29 October 2018

Planning Application Ref: R/197/18/HH – 1 Pigeonhouse Lane, Rustington

Drawing Number: 123 / P 106 **Rev.**

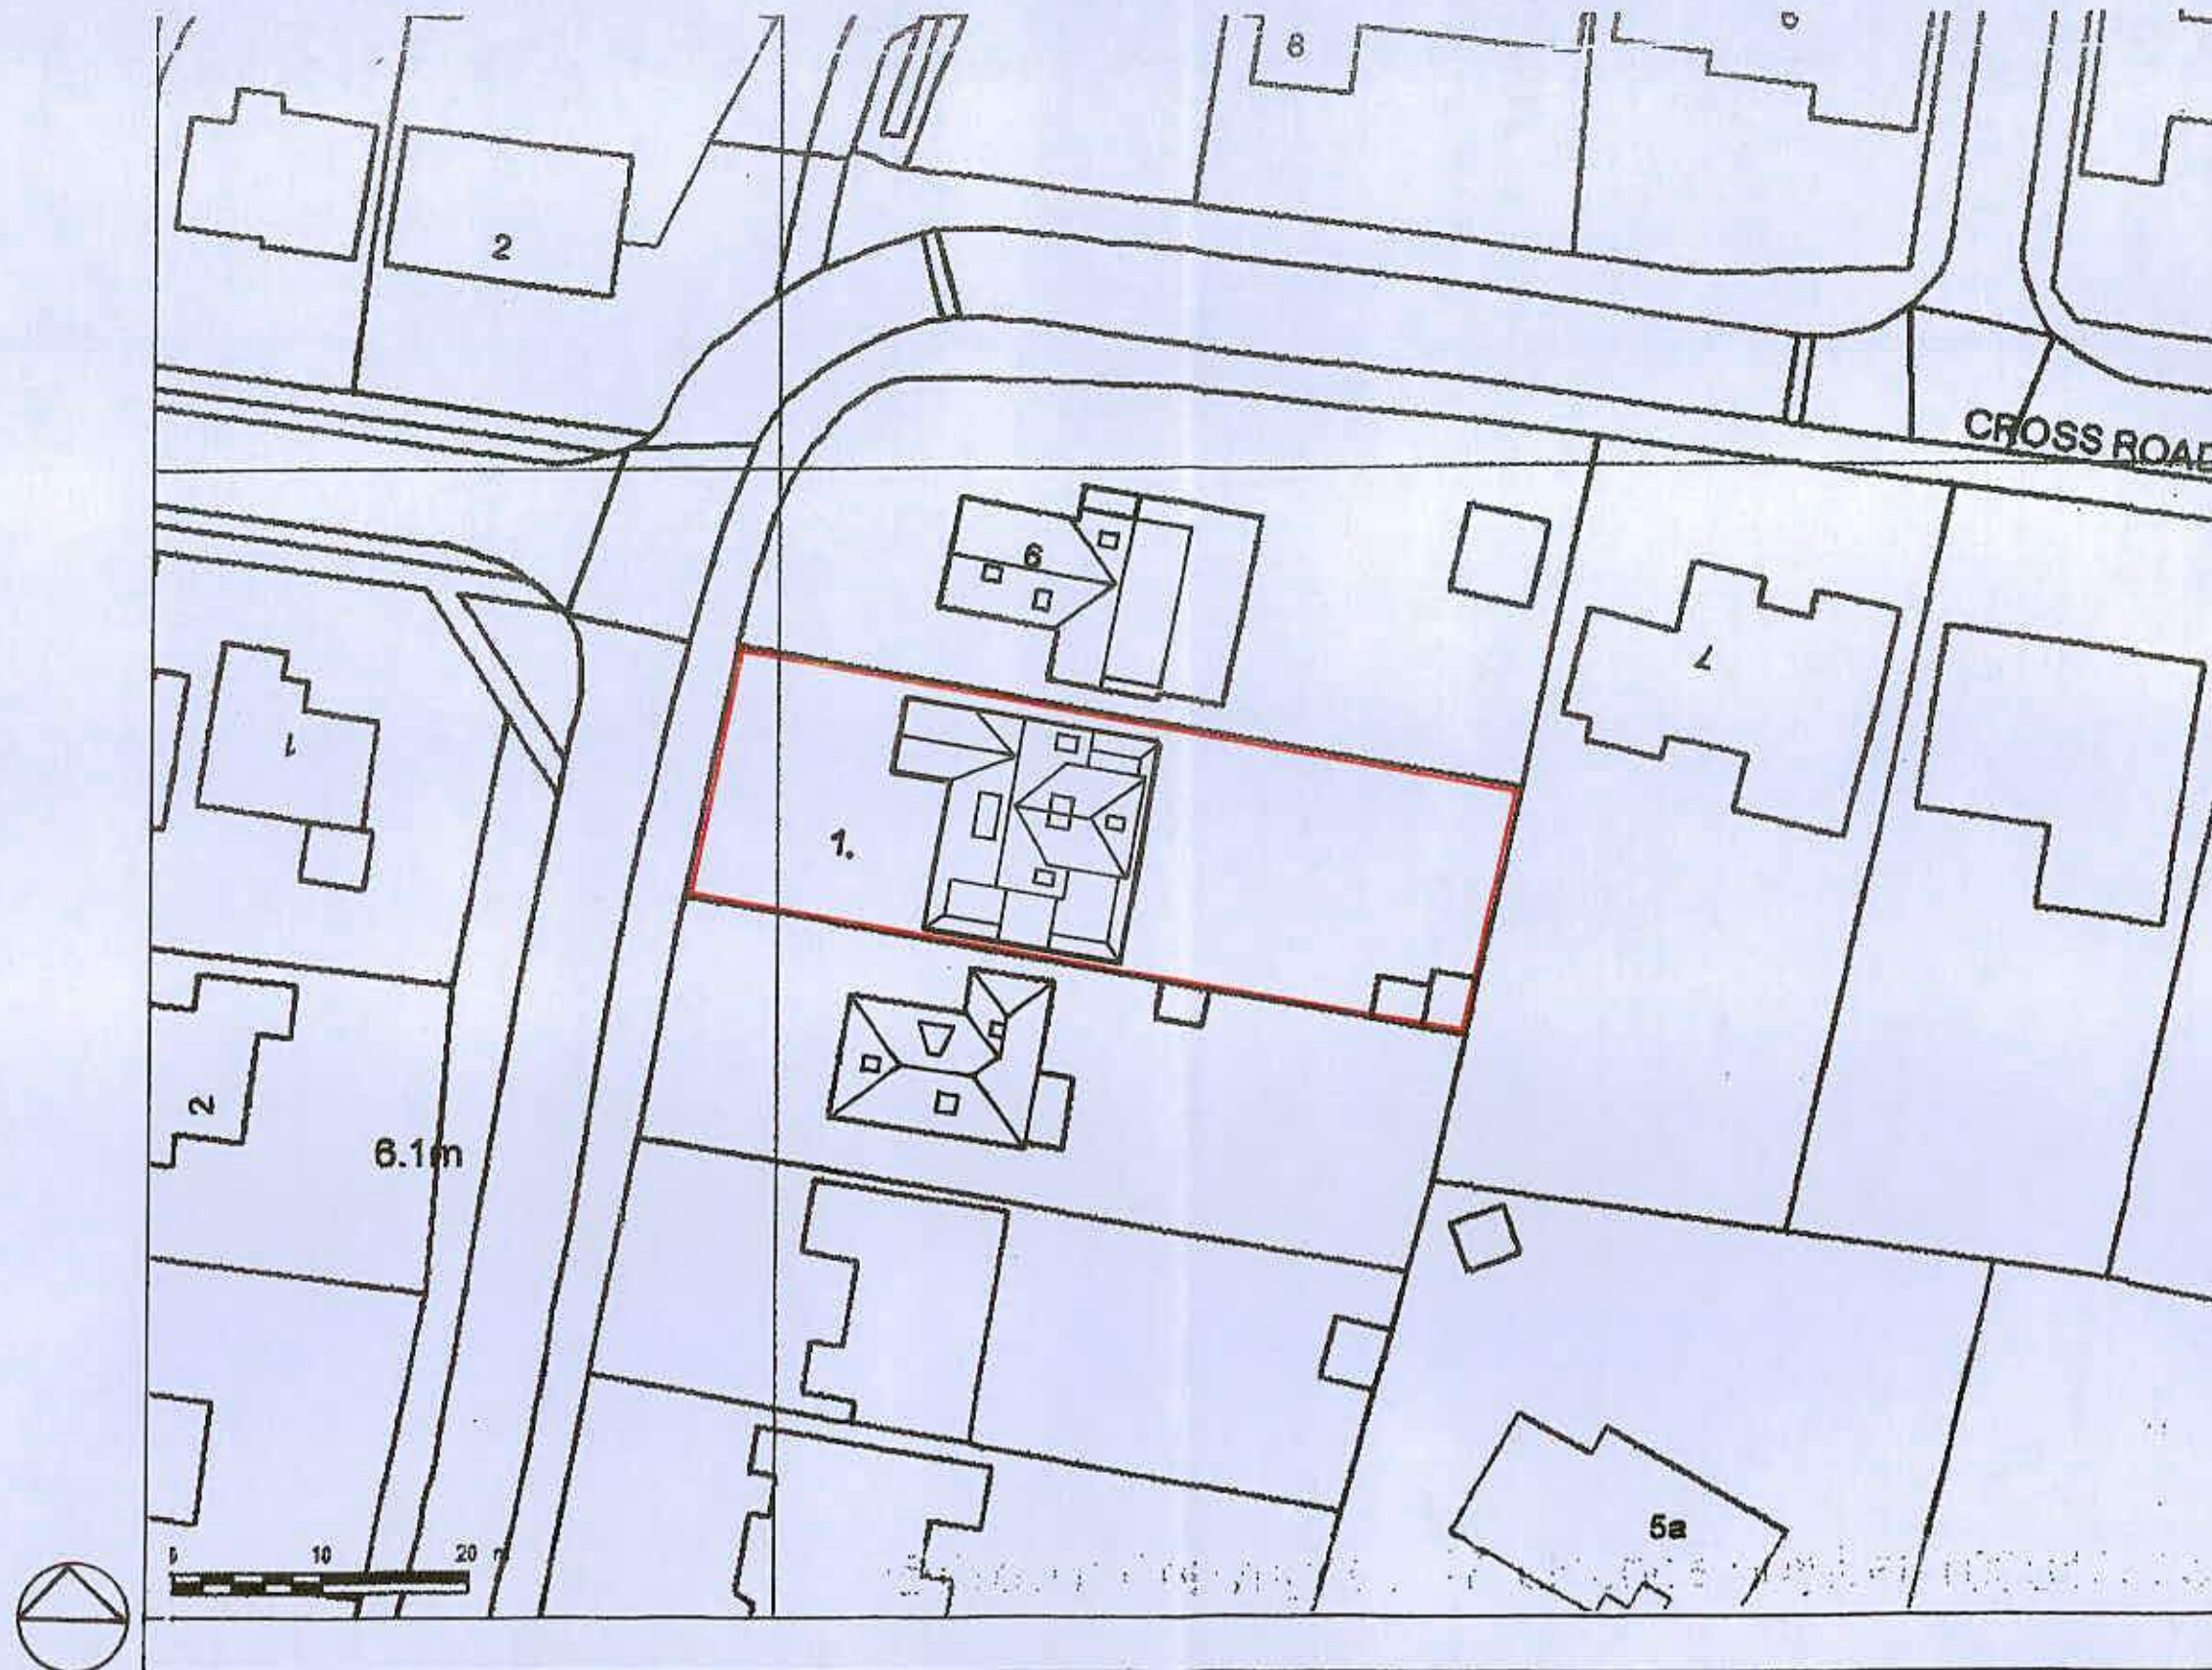
- The plans do not include contextual proposed elevations demonstrating the relationship to and impact on the two immediately adjacent buildings.
- The revised block plan 123/P106 omits the boundary distance from 1PL to 9CR.

- Block plan 123/P106 omits the new roof window at the front on the west elevation which is included in drawings 123/P113, 123/P114 and 123/P115.
- The application form states incorrectly that the existing roof materials are slate when in fact they are red roof tiles. No other information has been included in the application about materials to be used.

Drawing Number 123 / P 116 **Rev.**

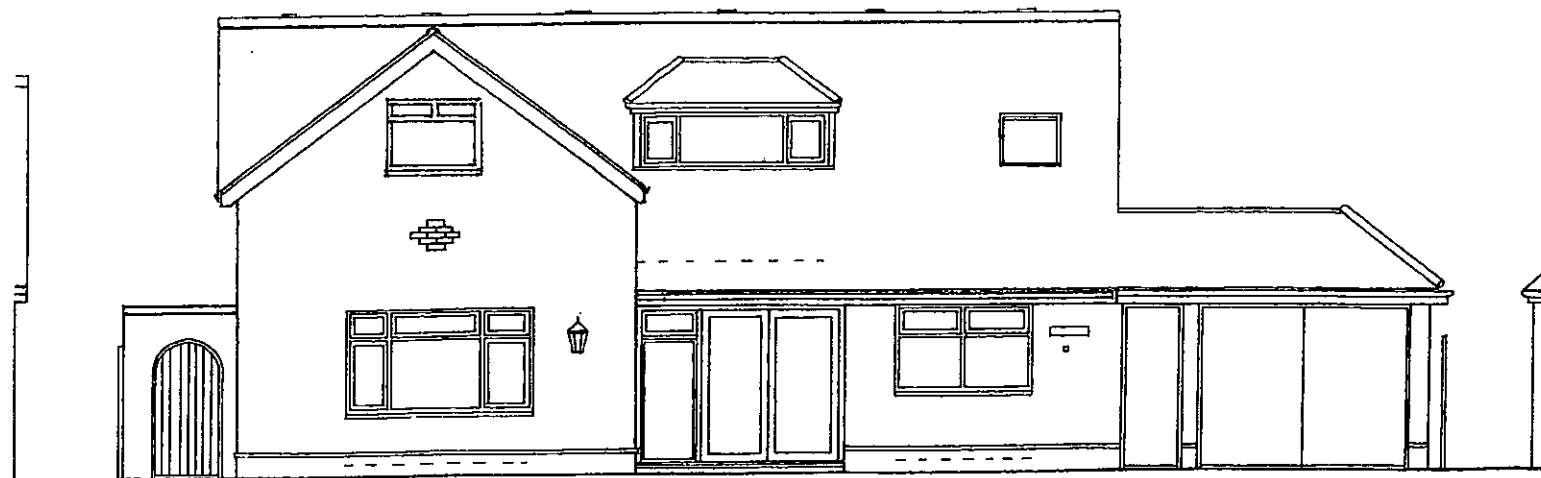
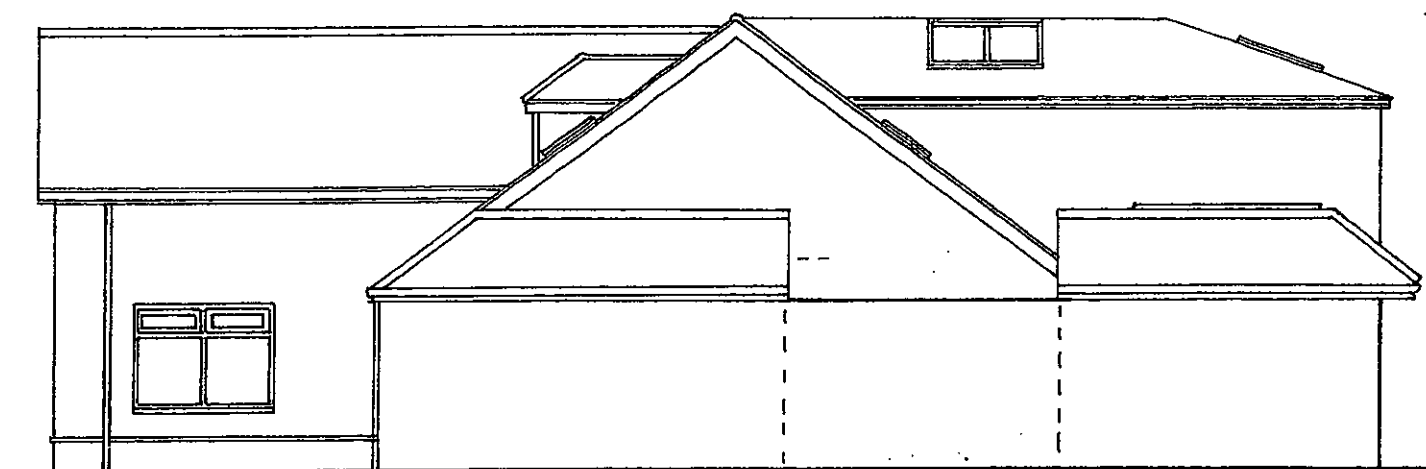
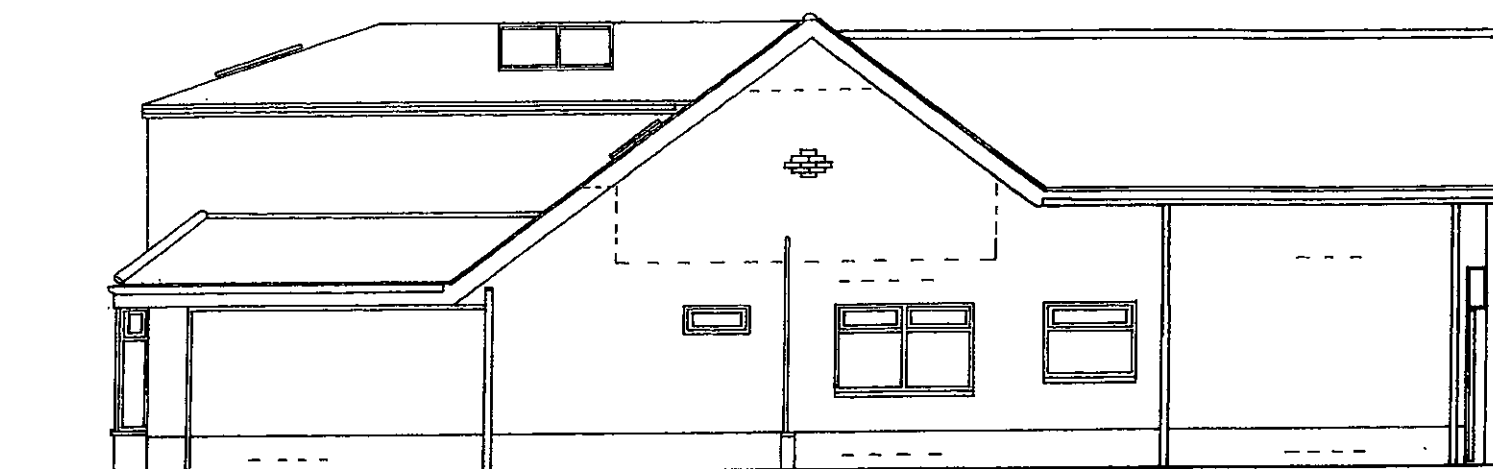
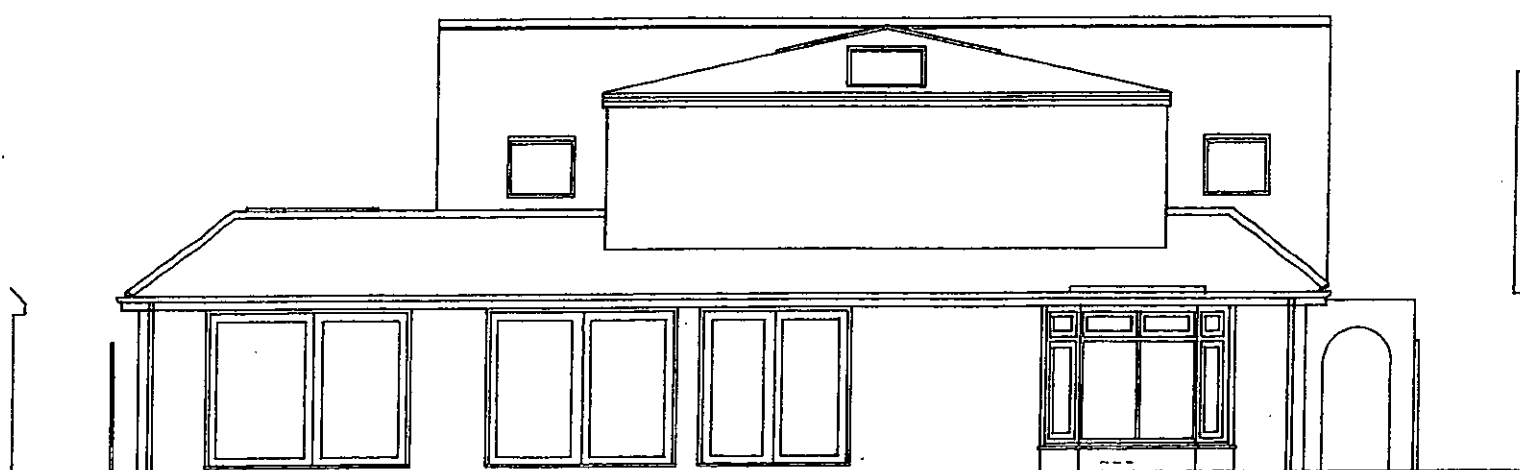
overlook that was only oblique in nature. This converted 1PL into the five bedroom, four bathroom property which it already is today. The current proposals for the windows at the rear show that the roof window closest to our southern boundary on the east elevation (drawing 123/P116) is only 0.5 metre from the edge of the roof and would therefore directly look into our lounge window and beyond. This overlooking is not oblique in nature and is an unacceptable intrusion on our privacy and represents an undoubted loss of amenity. This will be even more pronounced if the roof window (like the existing roof windows) is a top-hung "velux" style with the sill around waist level, fully openable and the glass not opaqued. Furthermore, we would not be able to mitigate this overlooking by planting owing to the narrowness of the external corridor between our property and the boundary fence. In any event, planting of this height would also cut out the very light we wish to retain in the main living areas.

- The increased height of the gable wall on the northwest and resulting increase in roof height varies – eg. drawing 123/P116 shows the wall increasing by a height of 1.0 metre and lying below the existing roof ridge, yet in drawing 123/P115 it increases by 1.2 metres so that the roof matches the existing roof ridge at a height of 3.7 metres. The Design Commentary dated November 2017 and attached to the previous application to the Willowhayne Residents Association "proposed to raise the existing gabled front projection by some 1.2 metres".
